From: Planning
Subject: FW: 3/2021/0203

From: Brenton, Robert <
Sent: 17 June 2021 08:36
To: Adam Birkett <
Cc: Planning Liaison
Subject: RE: Consultation on planning application 3/2021/0203 Old Row, Whalley Road, Barrow BB7 9AZ
DC/21/2128

S104 Drainage Layout

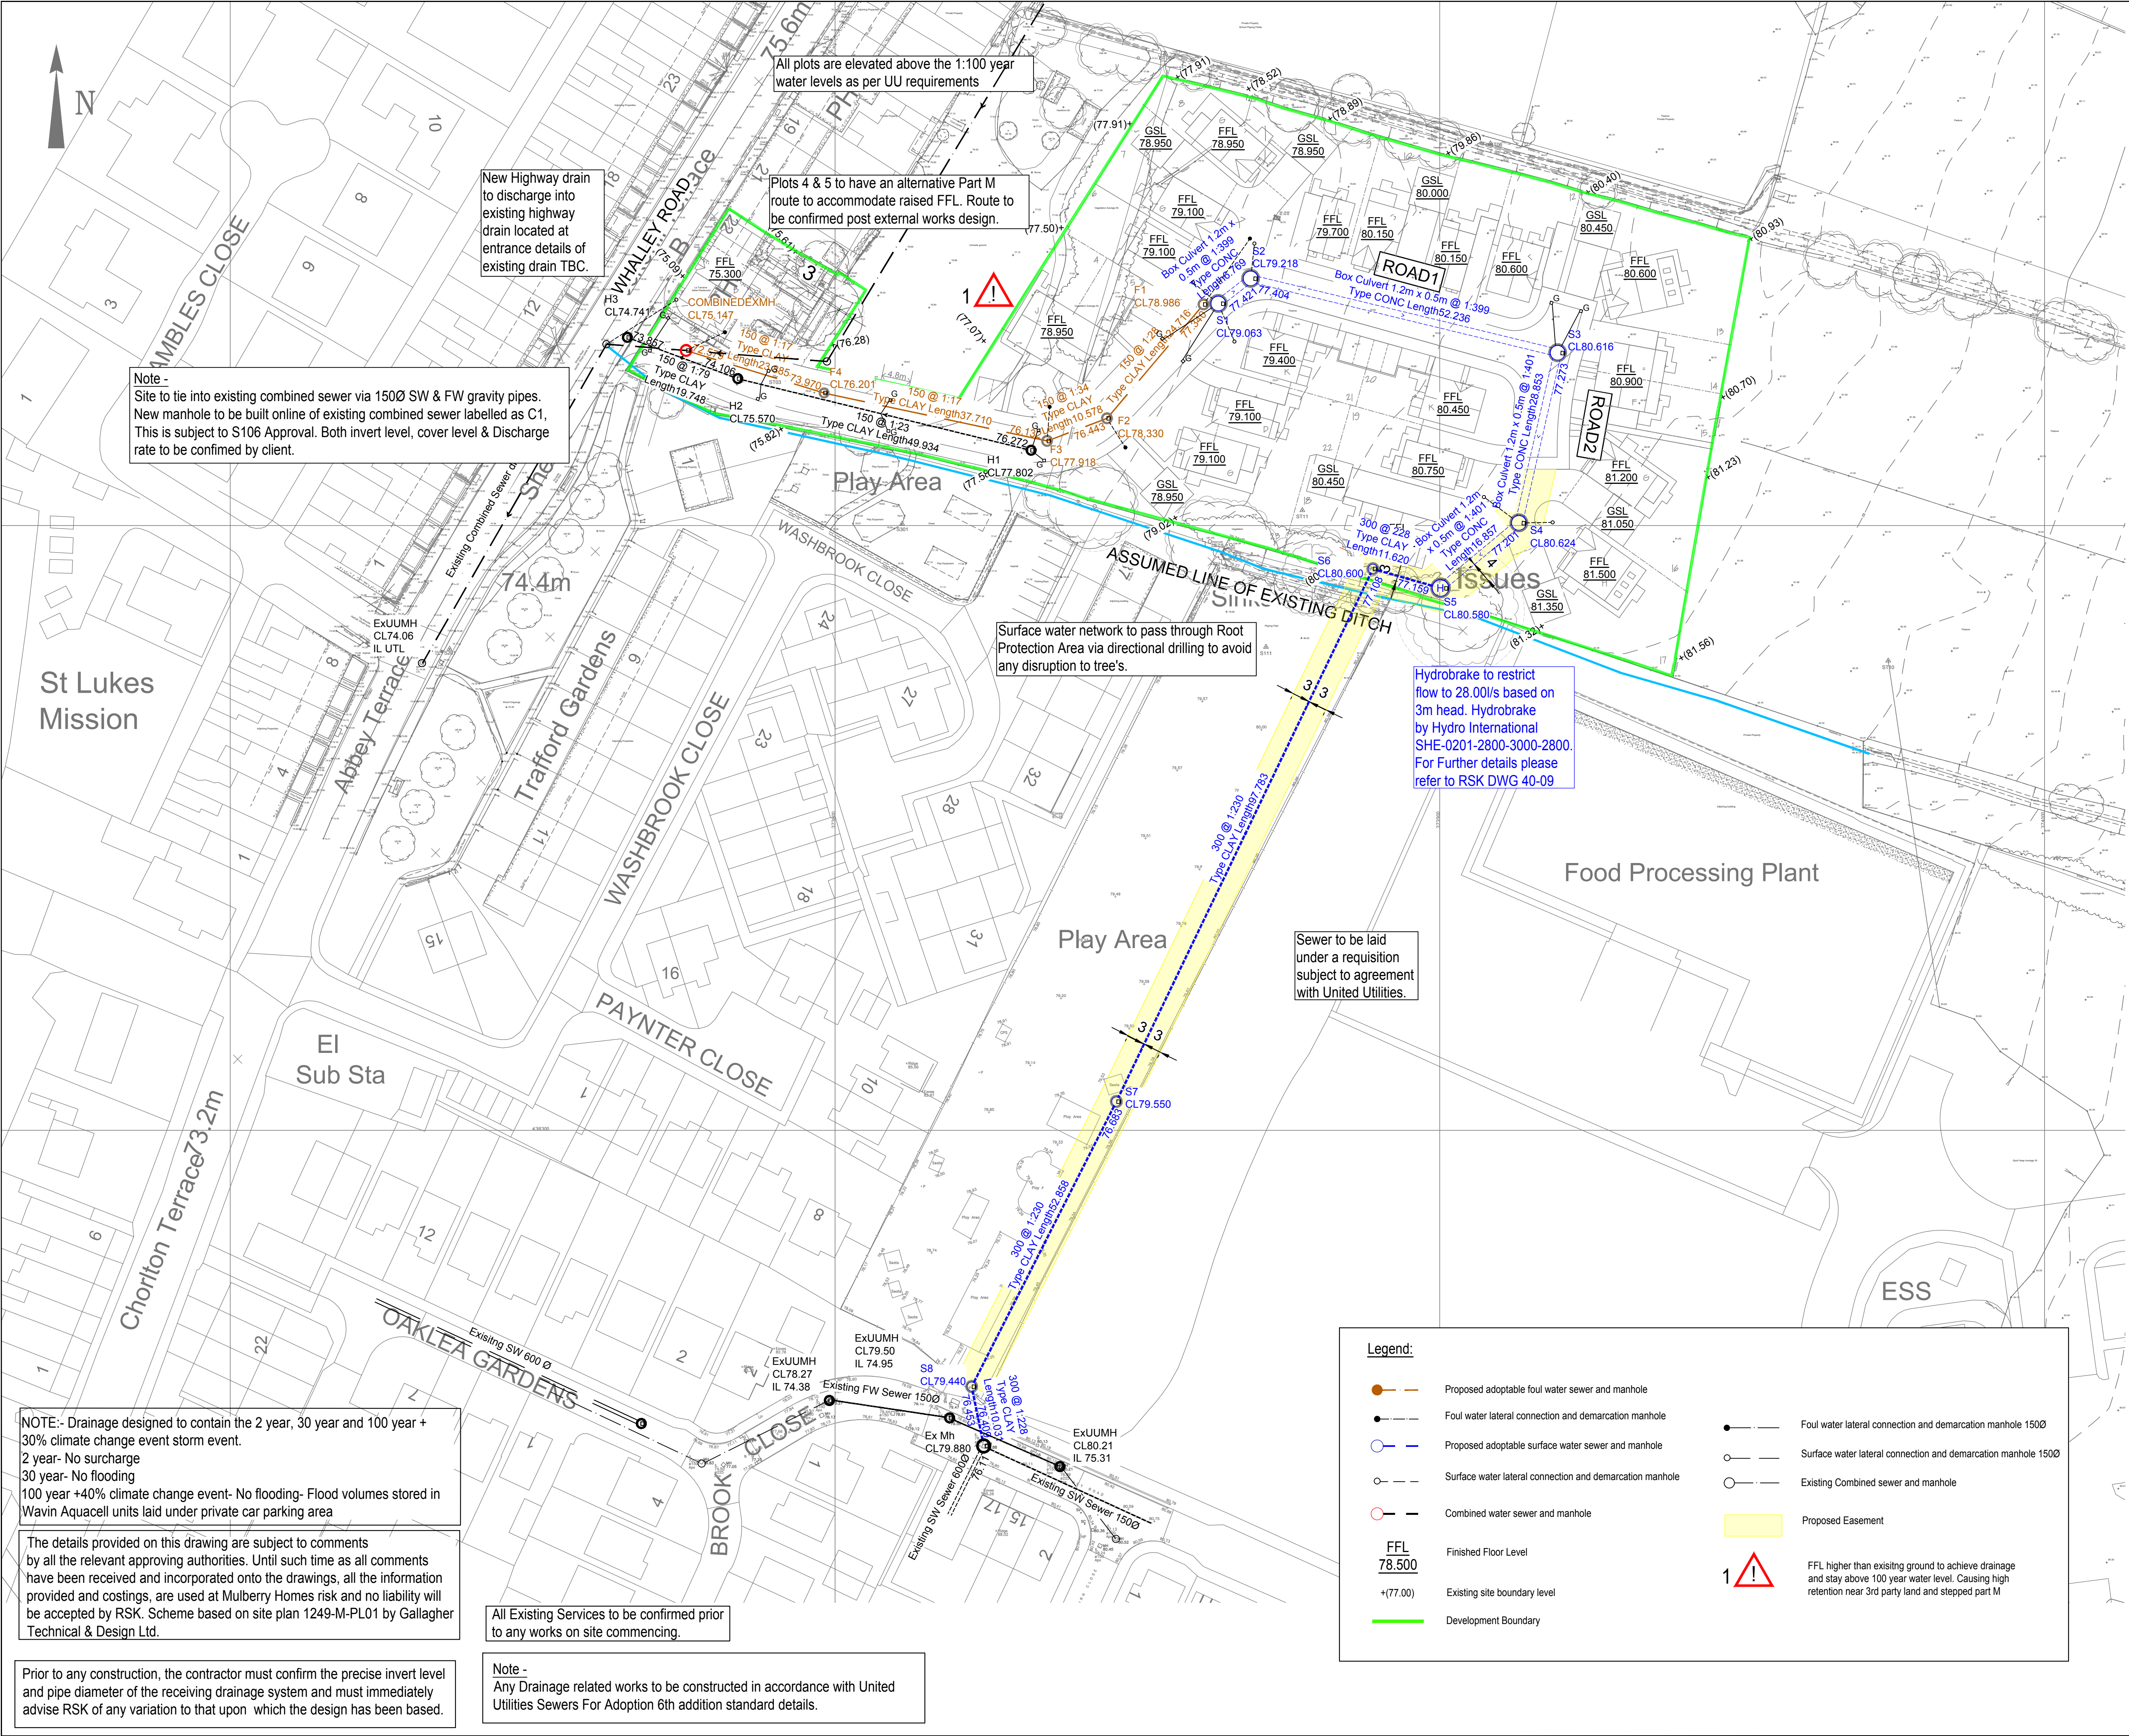
Apologies for the delayed response. Following an assessment of the provided proposed Drainage Layout, Ref: 881590-ENG001, Rev: P10, Dated: 09.04.2021, By: RSK in support of the planning application (our ref: DC/21/2128), United Utilities concur with the LLFA's comments, the proposals appear agreeable in principle, subject to the points raised by the LLFA being addressed in addition to the following consideration: there are a number of instances where the Finished Floor Levels are below the cover level on the receiving proposed public sewer and therefore could result in the creation of a hydraulic low point, this should be addressed prior to determination. Con 7 (h).
